Leap of Faith Academy, III
Dawanda Burrus
804 W. Broad St.
Dunn, NC 28334

An application for the purposed child care, located at 804 W. Broad St. Dunn, NC, was received and has been reviewed. At this time additional information is requested in order to complete the plan review. Please provide the following:

Half Day Program
"Unlicensed Area"

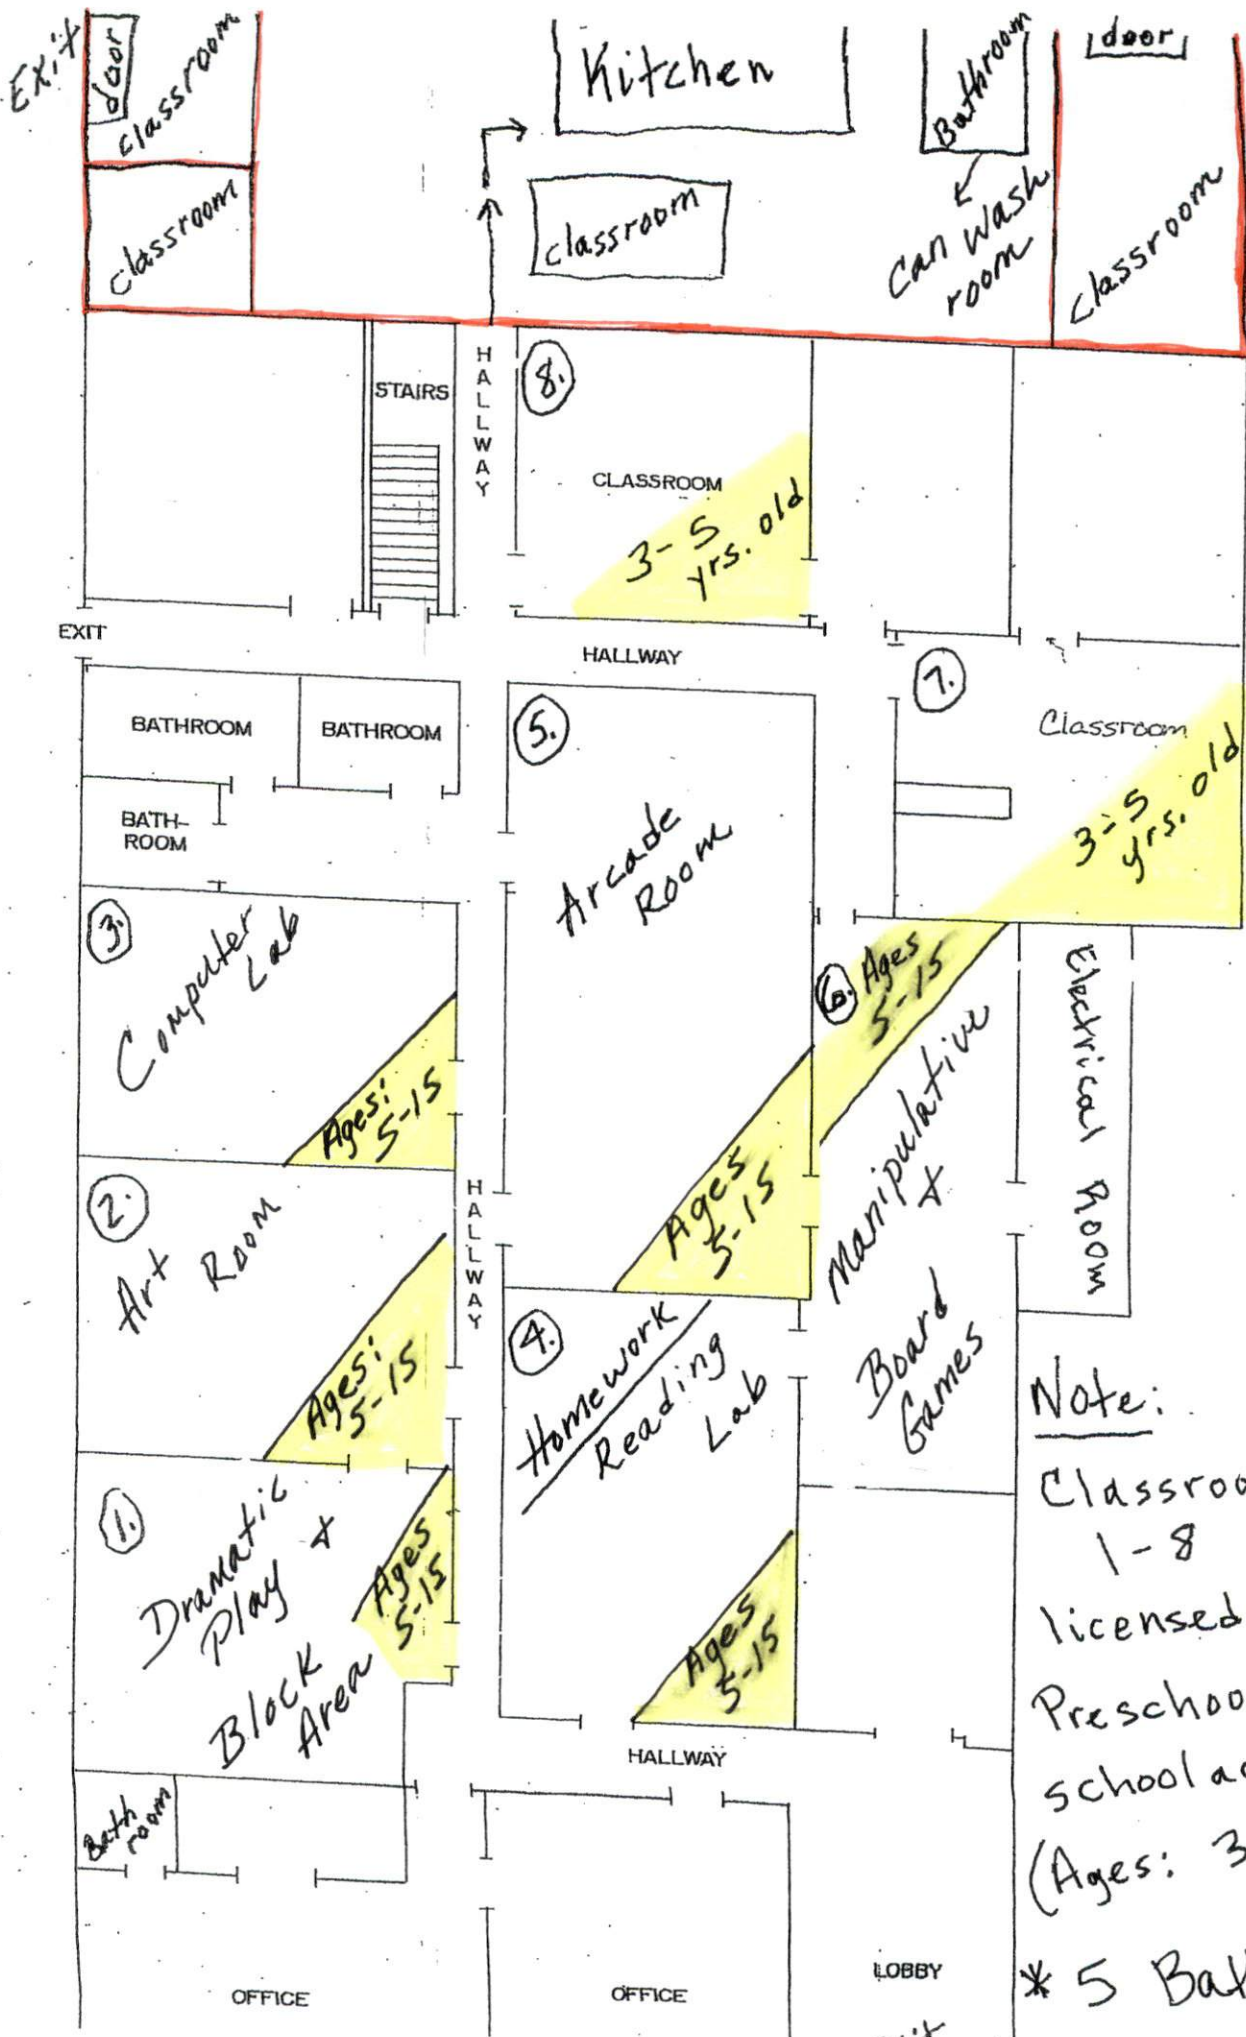
1. Provide a list of equipment in the kitchen and a corresponding equipment specification sheet for each piece of equipment.
2. Provide a drawing of the child care facility including placement of equipment, storage areas, food service areas, can wash facility. Identify the age groups that will be using the classrooms.

6. A separate handwashing sink from the dish sink is required in the kitchen. Indicate the location of the handsinks on the drawing. Additional handsinks may be required outside of those in bathrooms.
